RE: **Lot 15 Block 4 Unit 22 Volcano Cliffs SAD 228**  
**6423 Canavio St NW**  
**Grading and Drainage Plan**  
**Engineers Stamp Date 4/27/17 (D10D003D15)**

Based upon the information provided in your submittal received 5/9/17, this plan is approved for Grading Permit. **Prior to building permit approval the following comments must be addressed.**

ENGINEER'S SEAL 4/27/17 DAVID SOULE P.E. #14522	6423 CANAVIO PLACE	DRAWN BY WCWJ DATE 4-26-17 21731-LAYOUT-4-26-17
	GRADING AND DRAINAGE PLAN 1606 CENTRAL AVENUE SE SUITE 201 ALBUQUERQUE, NM 87106 (505) 872-0999	SHEET # — JOB # 21731

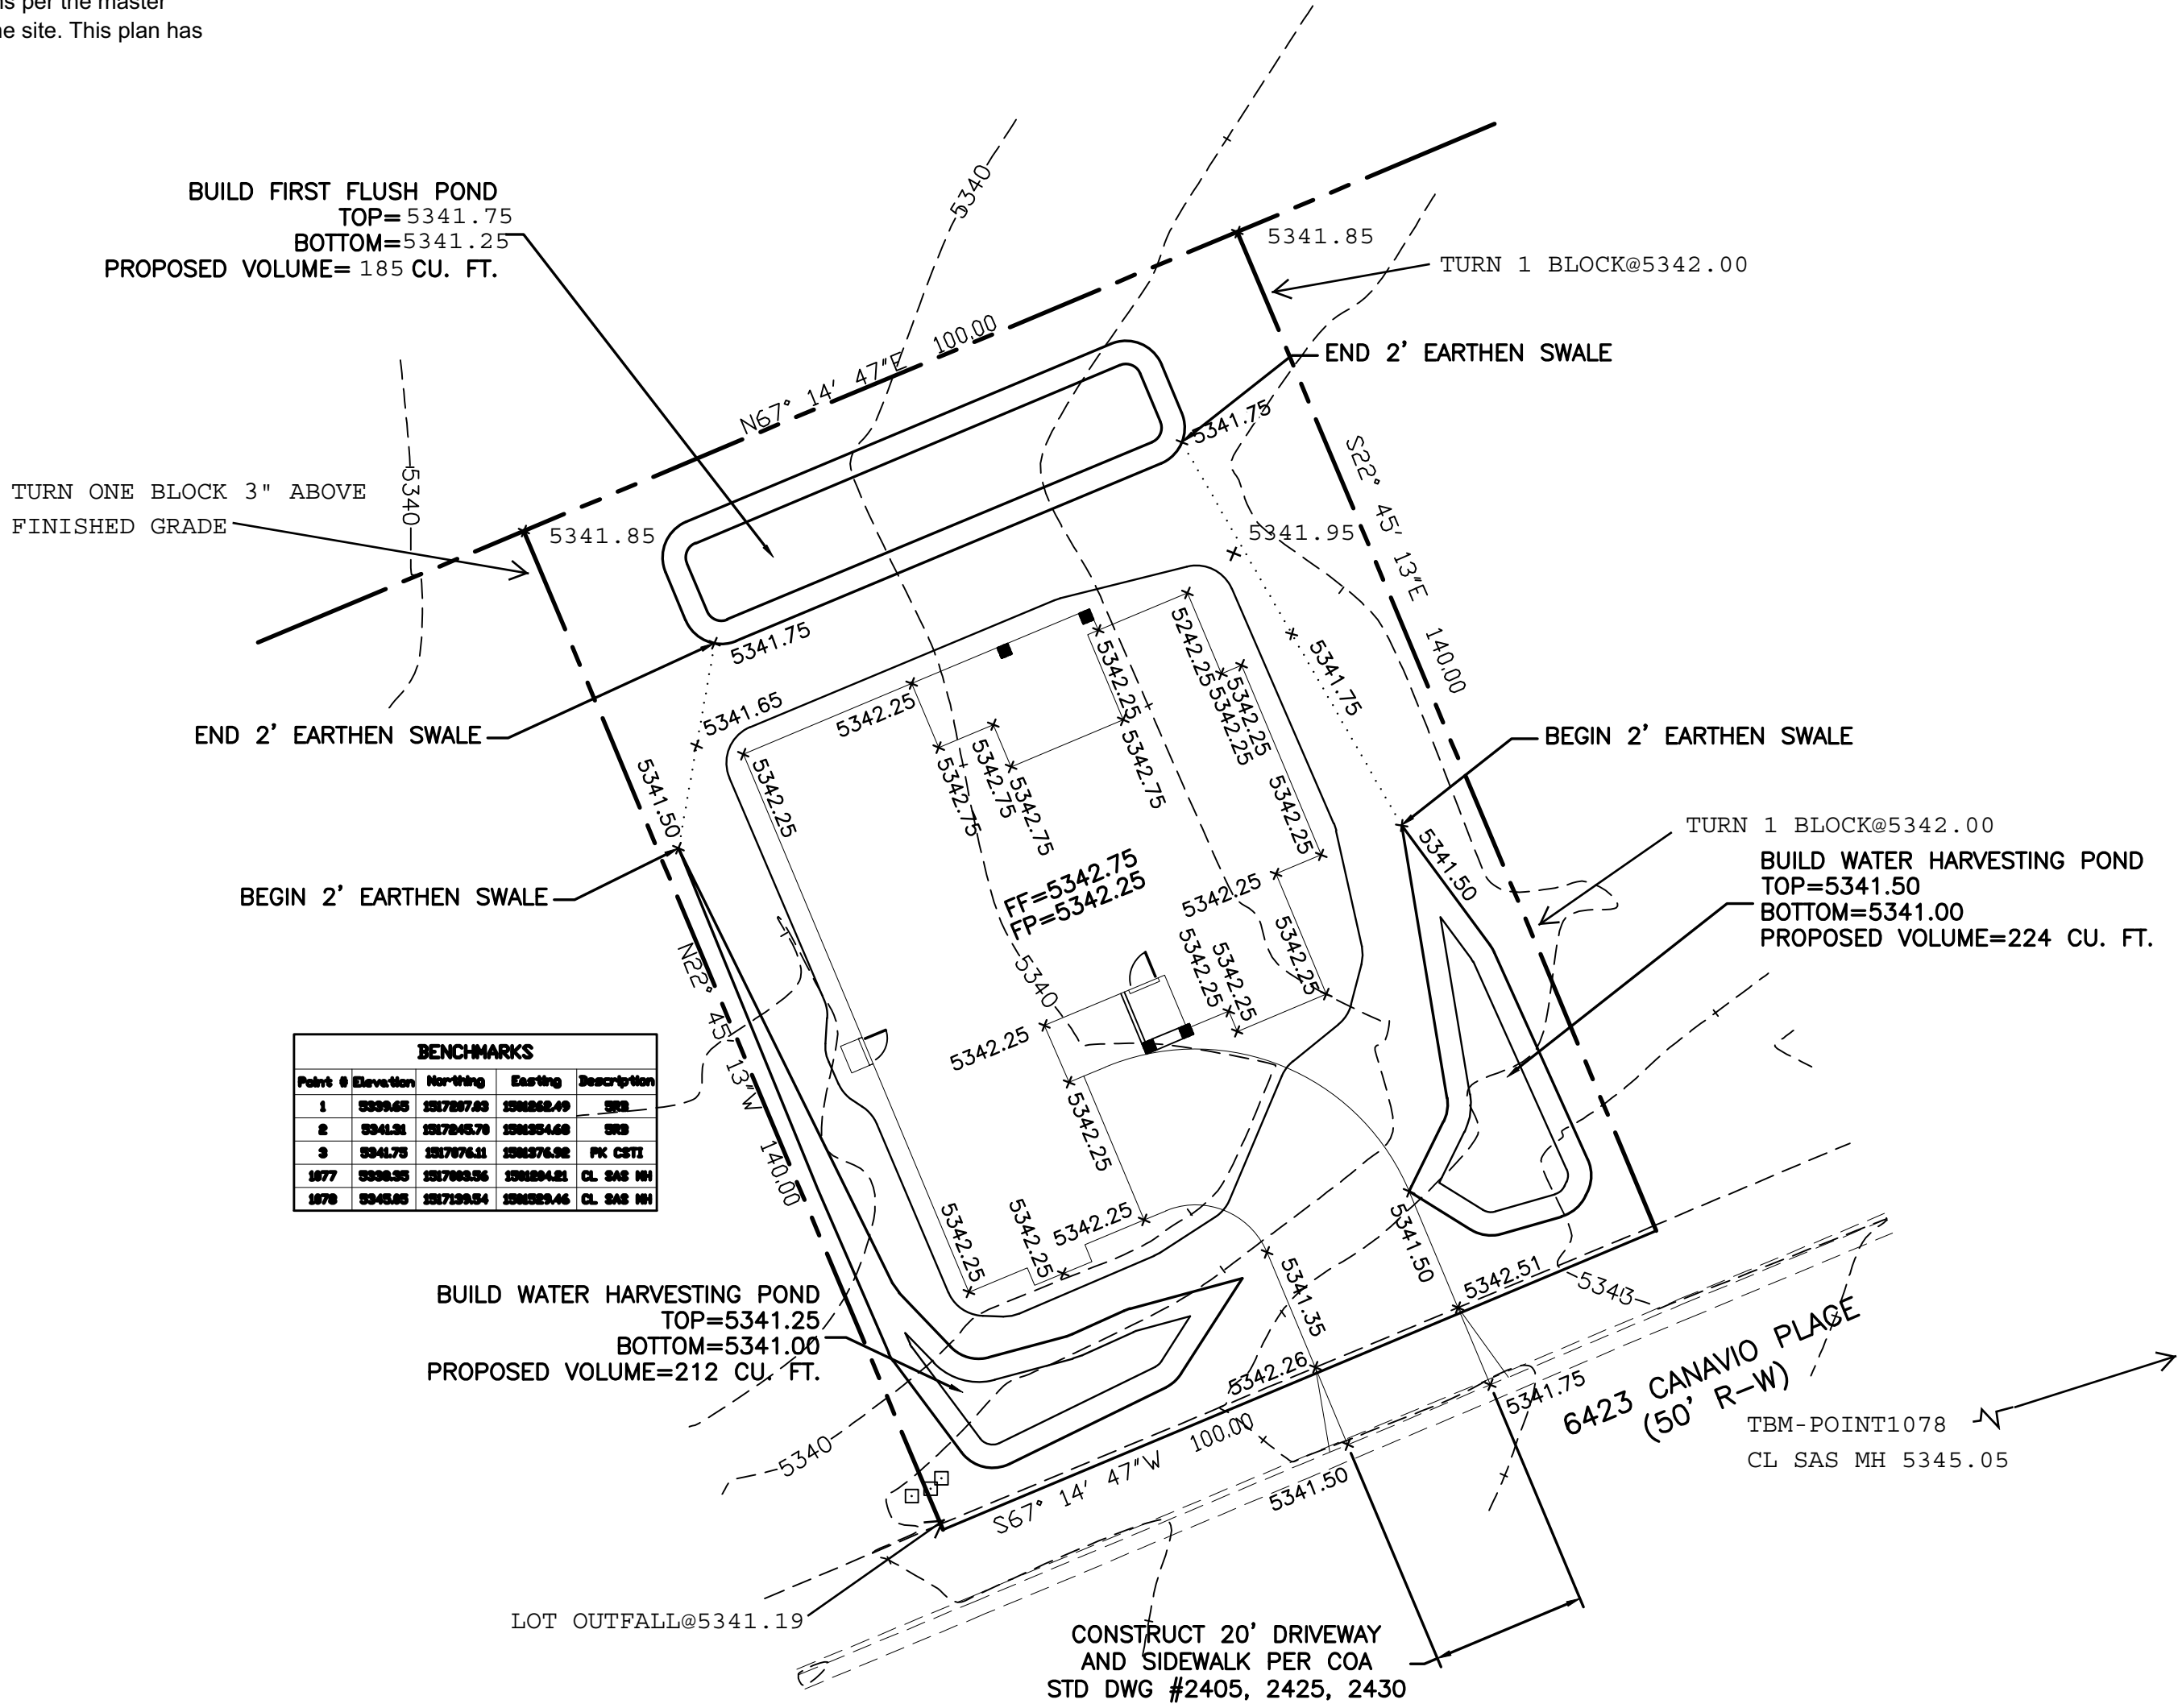
- Provide a pad certification.
- Provide an opening at the NW corner of the property, 3" above grade.
